EPC STORMWATER REVIEW COMMENTS
 IN ORANGE BOXES WITH BLACK TEXT

EL PASO COUNTY GRADING AND EROSION CONTROL PLAN CHECKLIST

DRAWING SCALE:
HORIZONTAL: 1" = 60'
VERTICAL: N/A

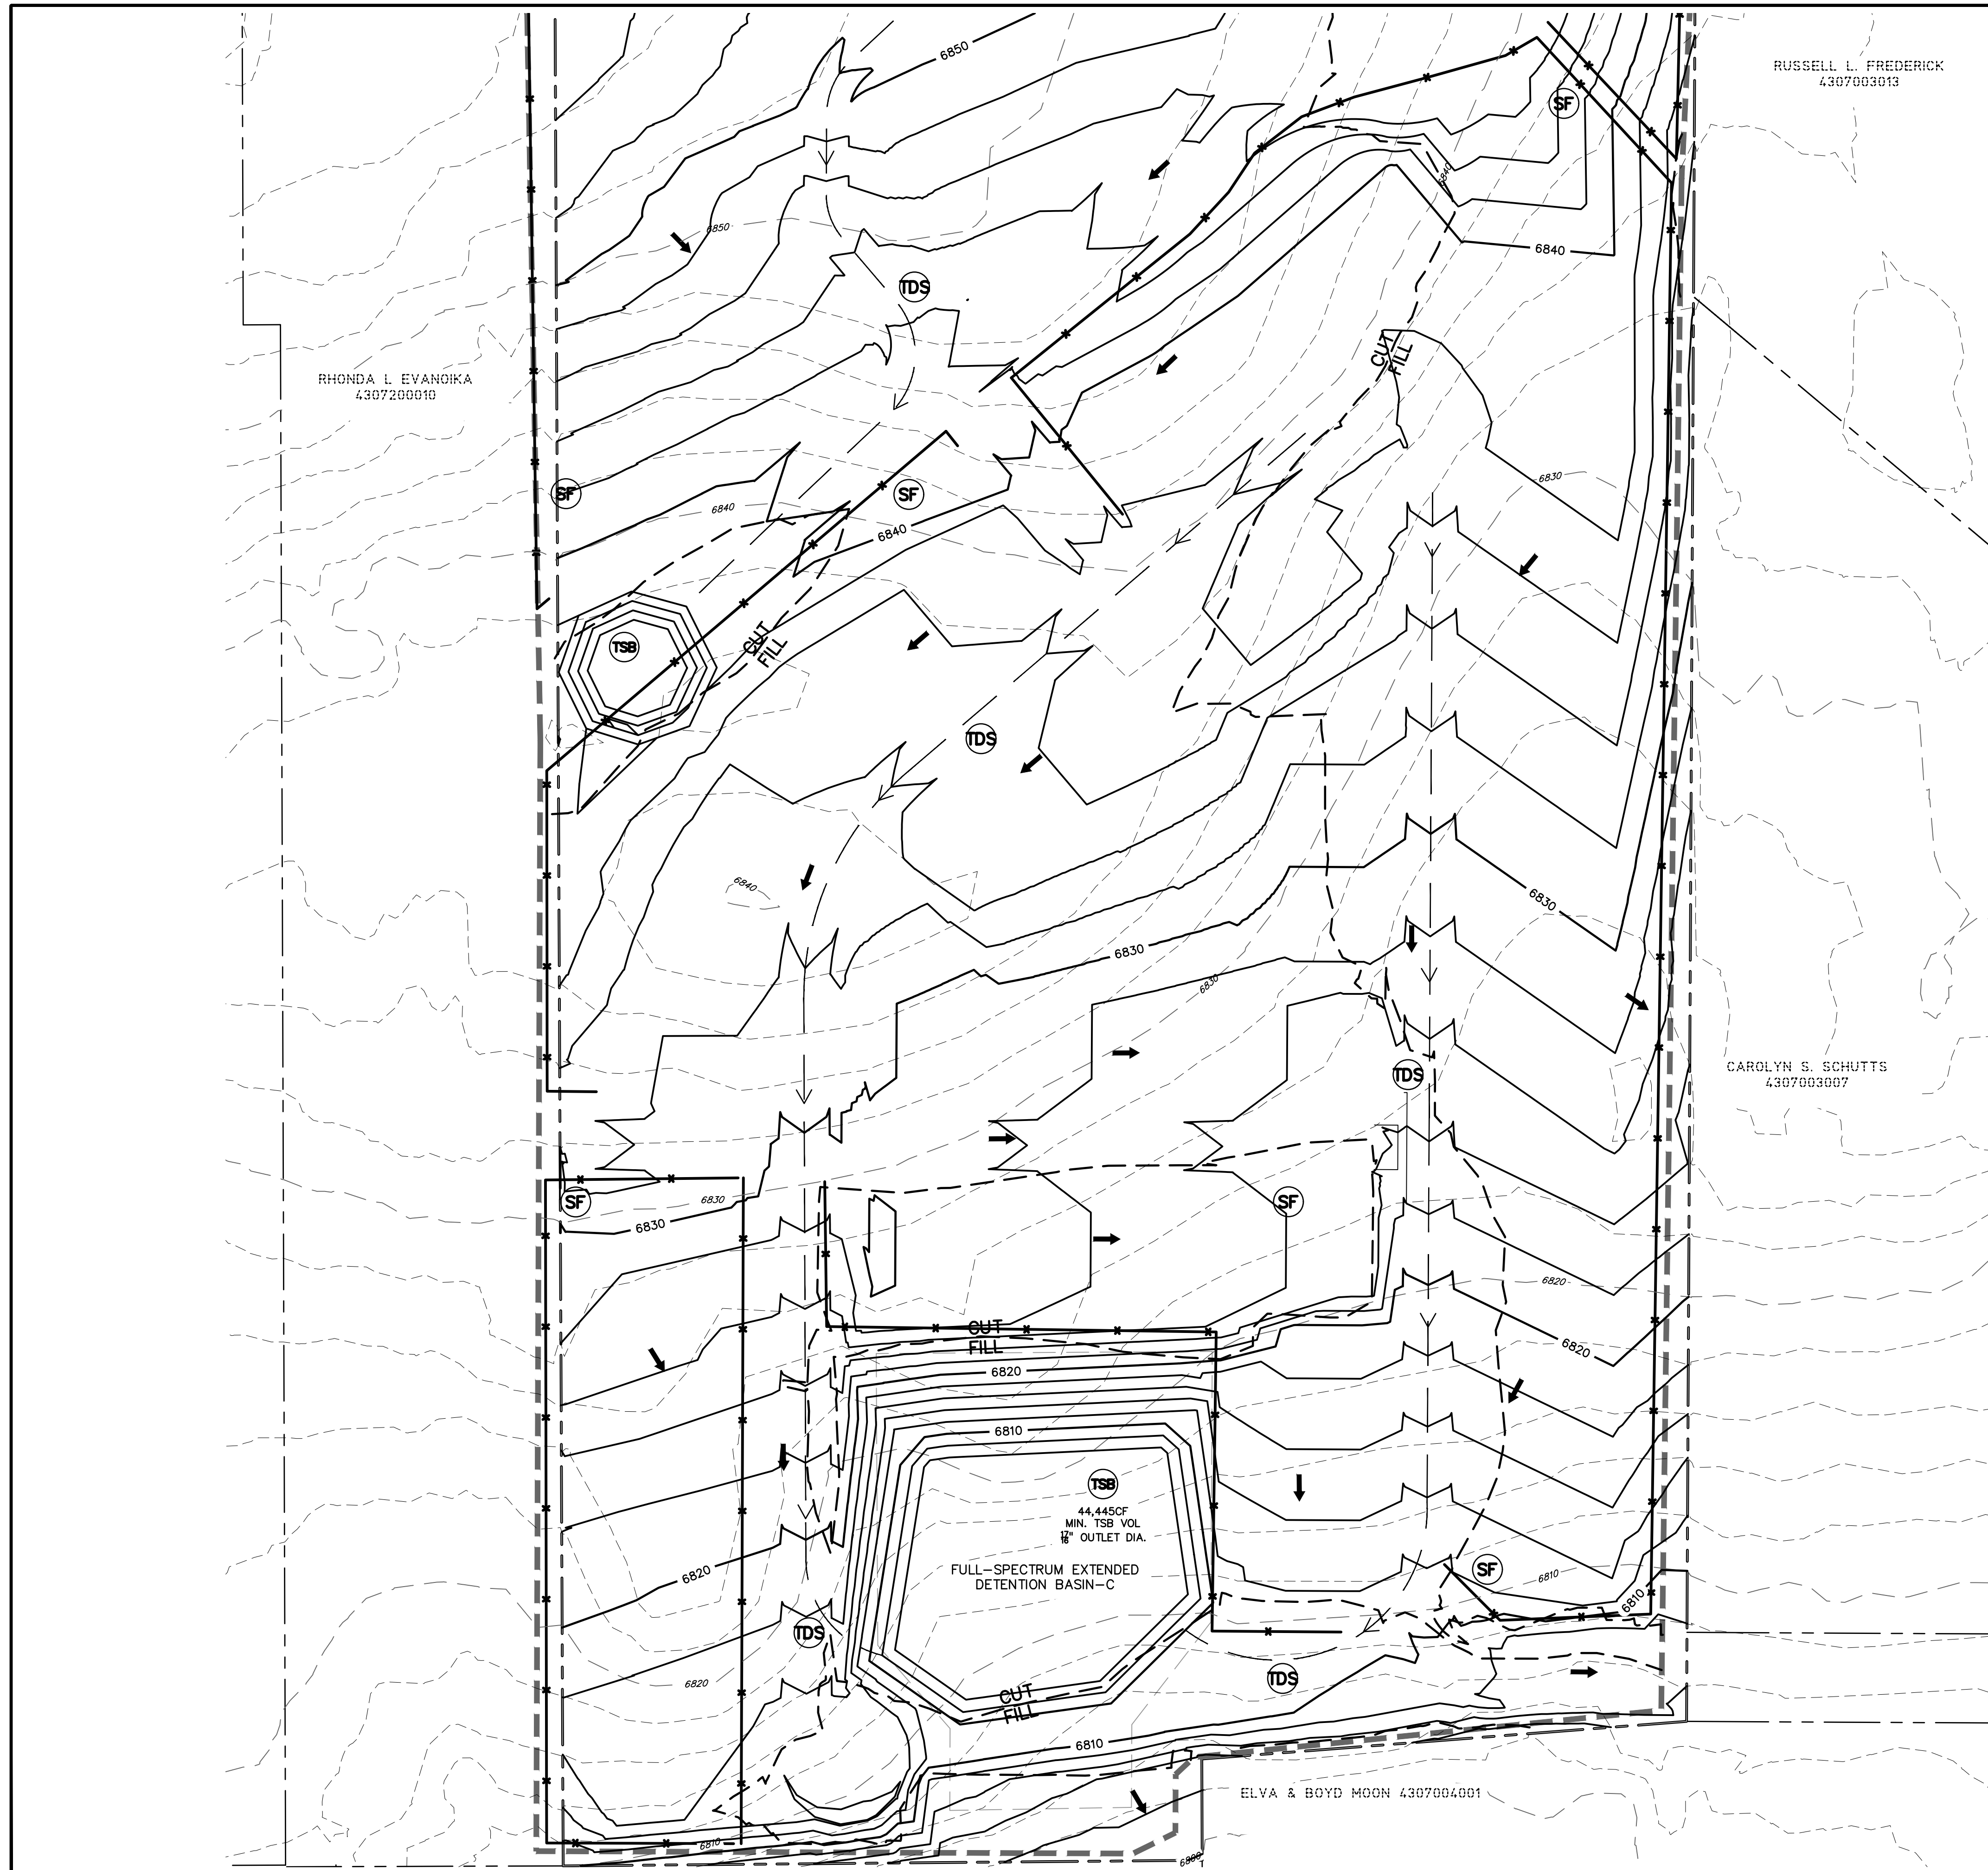
v	All proposed temporary construction control measures, structural and non-structural. Temporary construction control measures shall be identified by phase of implementation to include "initial," "interim," and "final" or shown on separate phased maps identifying each phase		N
w	Vehicle tracking provided at all construction entrances/exits. Construction fencing, barricades, and/or signage provided at access points not to be used for construction		Y
x	Temporary sediment ponds provided for disturbed drainage areas greater than 1 acre		Y
